Development Control
Ribble Valley Borough Council

Your ref: 23.0997
Our ref: D3.23.0997
Date: 6th March 2024

Address: The Royal British Legion Towneley Road Longridge

Proposal: Proposed residential development of 12 apartments (with restricted occupancy for residents aged 55 and over) following the demolition of the social club. Resubmission of 3/2020/0960

JOB NO 3391  
 DRAWING NO 120  
 REVISION D  
 SCALE 1:50 @ A1

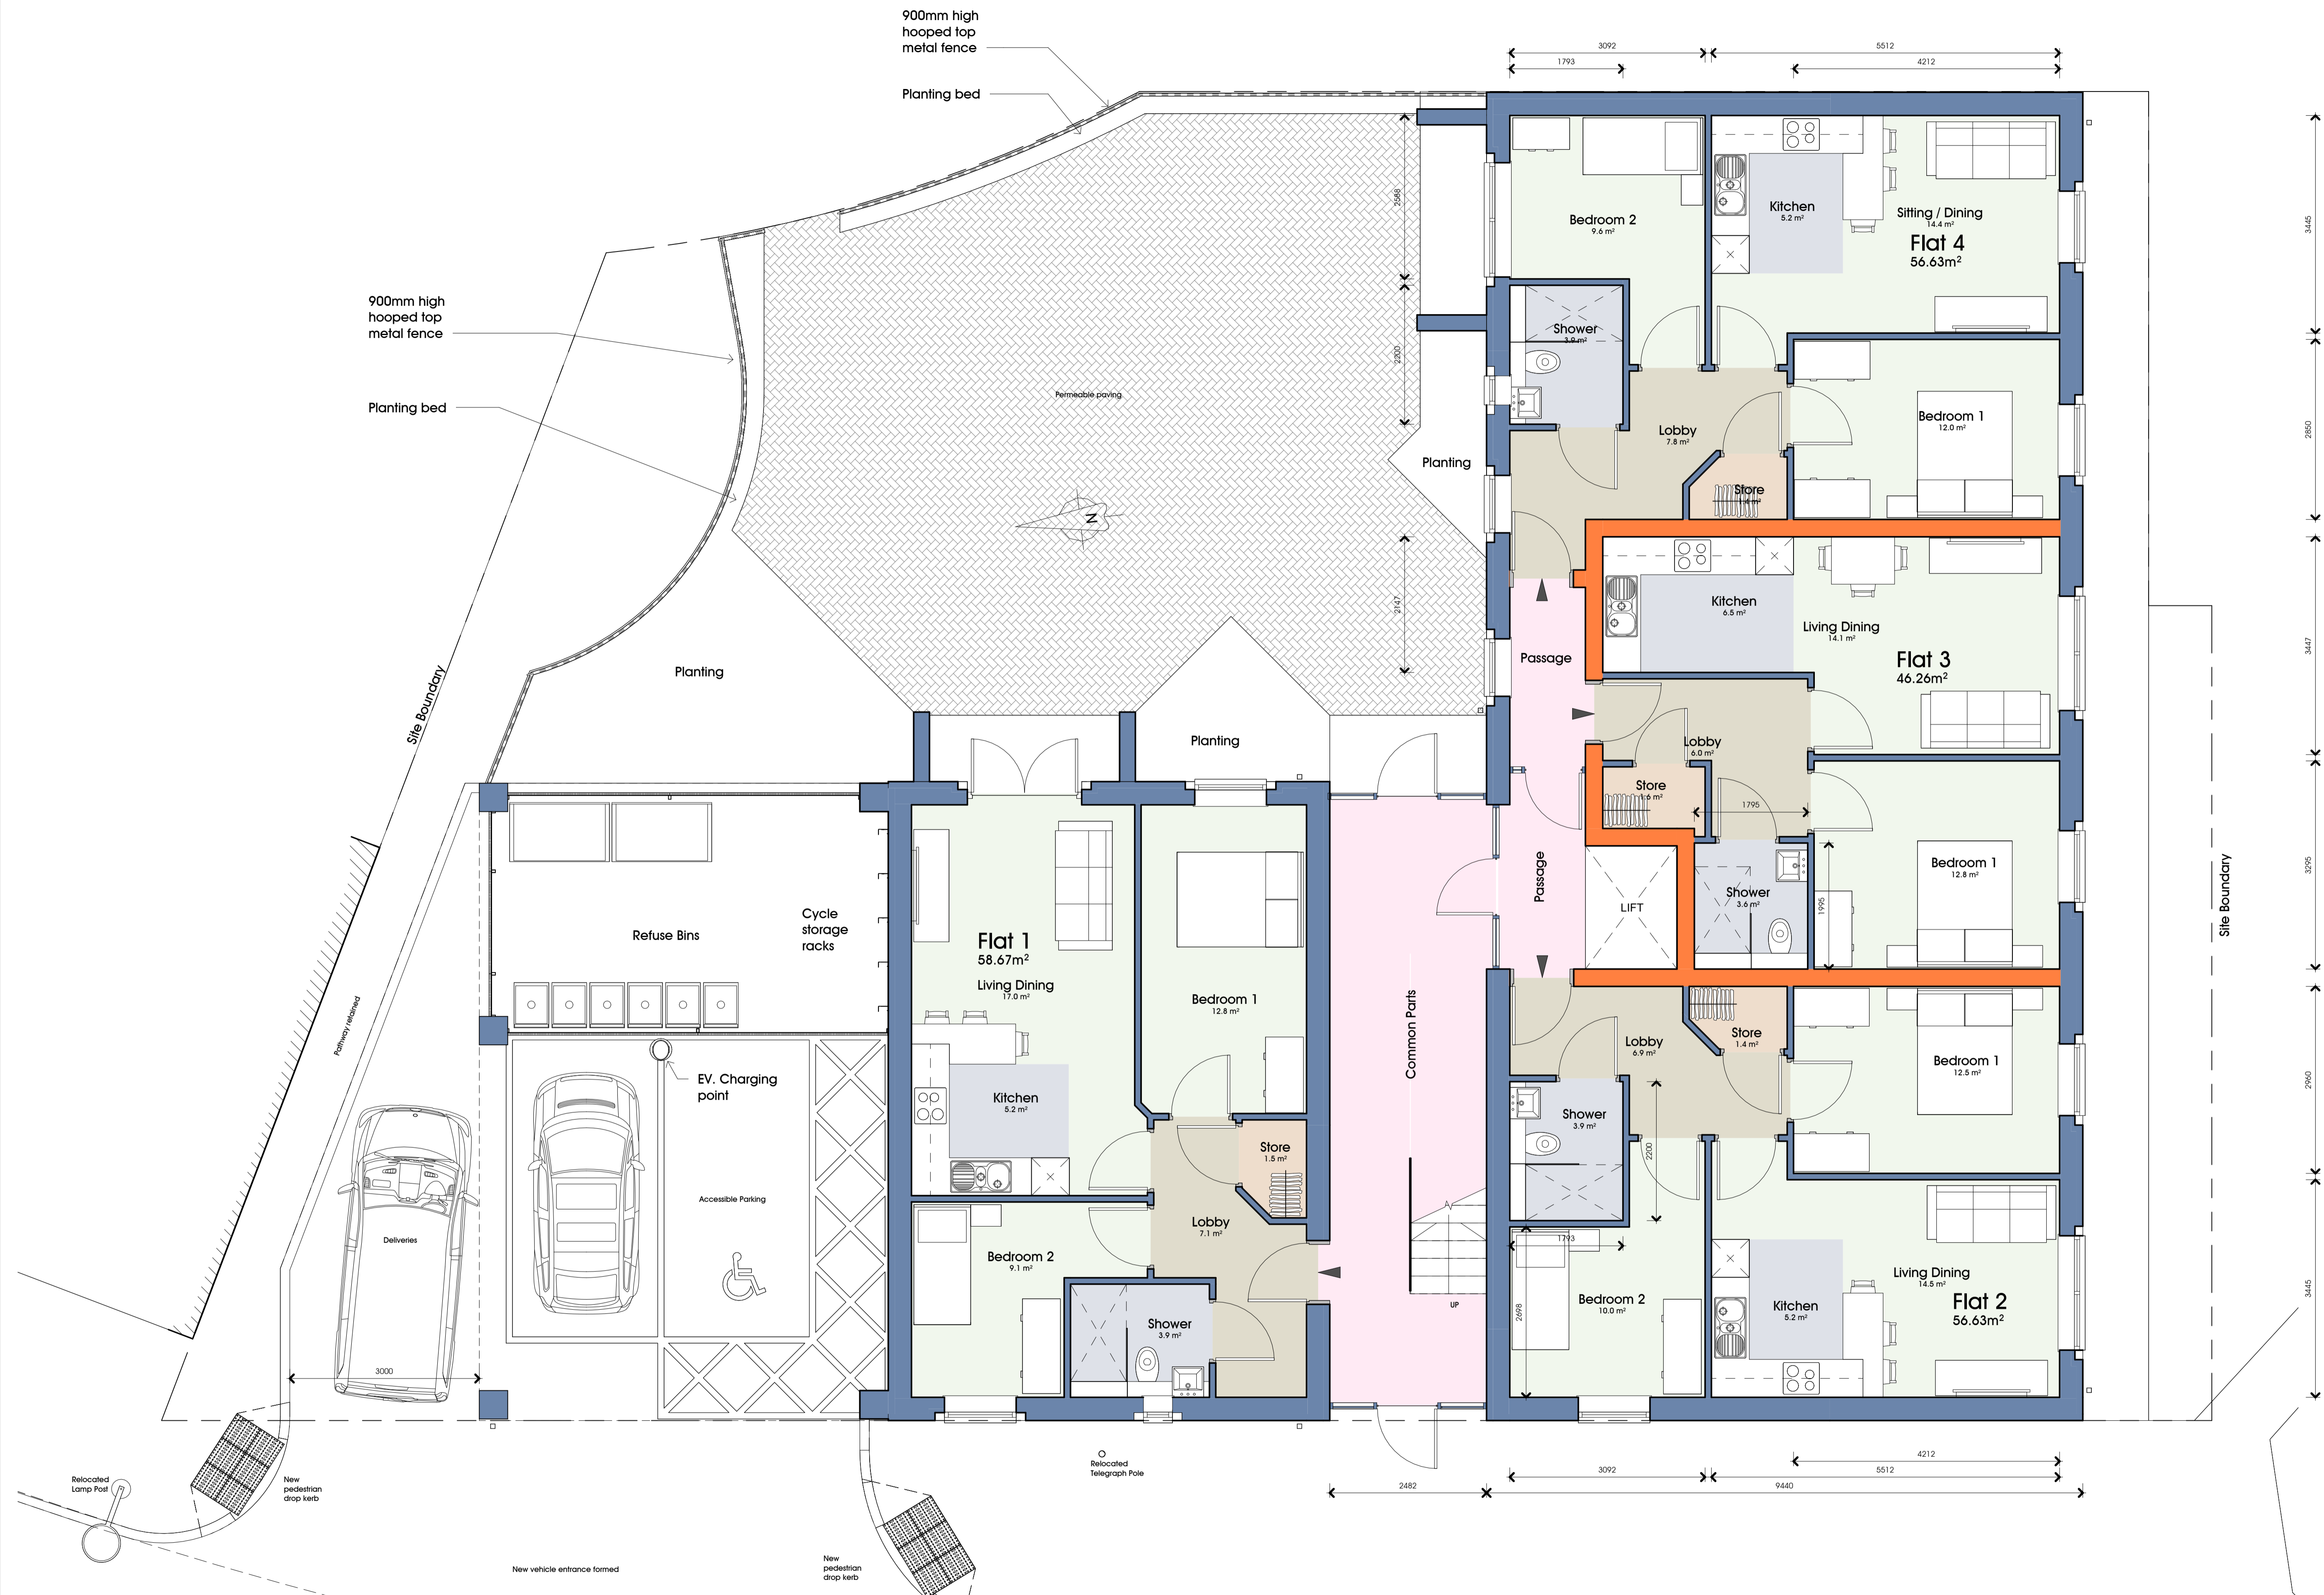
The submitted documents and plans including PGB Architectural Services 3391-120-ev D dated Nov 2023 – Planning Ground Floor/Site plan have been reviewed and the following comments are made. It is noted that many documents submitted include the previously refused layout including the Transport Statement, Drainage Assessment and Landscape plans.

There are 3 off-street car parking bays comprising a disabled bay, electric vehicle charging bay and delivery vehicle bay with a new access on Towneley Road. This is an increase of 3 off-street spaces from the previous application where there were no spaces proposed.

Towneley Road is unclassified and subject to a 20mph speed limit. There is a new access proposed to serve an off-street parking area for 3 vehicles. This will require a new vehicle crossing in the highway and the relocation of a street lighting column. These works will need to be carried out under a S278 agreement with Lancashire County Council.

There are 3 off-street spaces proposed at the site which would be designated for disabled badge holders, electric vehicle charging and deliveries. The disabled and electric vehicle charging bay are provided within the under-croft area.

There are 5 cycle racks within the covered area to the rear of the parking area with level access to Towneley Road, this area could potentially house mobility scooters if necessary.

2. Prior to the first occupation of the apartment block, the formation of the vehicle crossing and relocation of the street lighting column shall be completed under an appropriate agreement with Lancashire County Council Highways.

3. Prior to the first occupation of the apartment block the disabled, electric and delivery parking bays shall be constructed in a bound and porous material and be appropriately signed and marked for that purpose and maintained thereafter for that purpose.
